**KIRKLEES METROPOLITAN COUNCIL
INVESTMENT & REGENERATION SERVICE**

**DELEGATED DECISION FOR DISCHARGE OF CONDITION A.4 -
NOTIFICATION OF A PROPOSED ENLARGEMENT TO DWELLINGHOUSE**

Reference no.	2026/HH/90092/E
Site Address	8, St Mary's Walk, Mirfield, WF14 0QB
Description	The proposal is for erection of single storey rear extension. The extension projects 8m beyond the rear wall of the original dwellinghouse. The maximum height of the extension is 3.5m, the height of the eaves of the extension is 2.5m
Recommending Officer	Joanna Rednall

DECISION – PRIOR APPROVAL REFUSED

SITE PLAN
SCALE 1:500
DRG NO. 25198

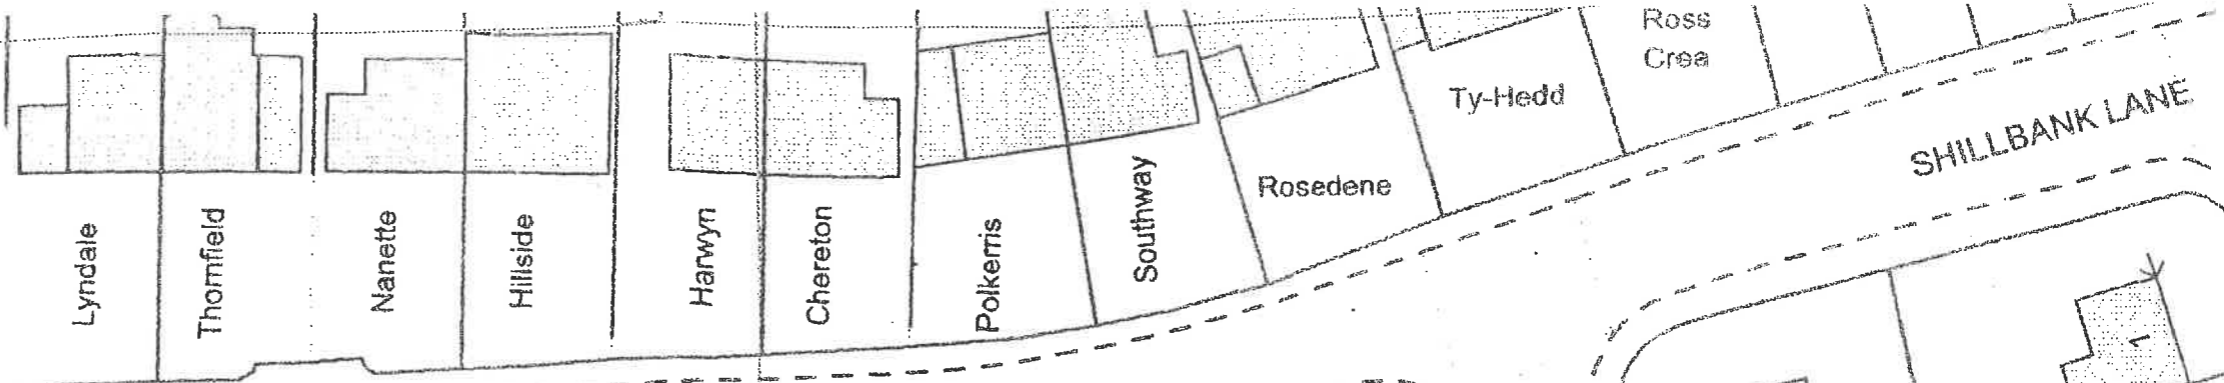
The submitted plans show the rear garage would be demolished to facilitate the extension sought under this application although nonetheless the rearward projection does consist of a wall that does form part of the original side elevation. Consequently, the proposed enlargement would extend beyond this side elevation and also has a width more than half the width of the original dwellinghouse contrary to paragraph (j) of the Town and Country Planning (General Permitted Development)(England) Order 2015 (as amended).

Sub- paragraph (d) of Class A, Part 1, Schedule 2 of the Town and Country Planning (General Permitted Development) (England) Order 2015 (as amended) provides that development is not permitted where the height of the eaves of the part of the dwellinghouse enlarged, improved or altered would exceed the height of the eaves of the existing dwellinghouse. In this instance, the eaves of the proposed rear extension would measure approximately 2.8 metres in height, whereas the eaves of the existing dwelling measure approximately 2.5 metres. Consequently, the proposed enlargement would exceed the height of the eaves of the existing dwellinghouse contrary to paragraph (d) of the Town and Country Planning (General Permitted Development) (England) Order 2015 (as amended).
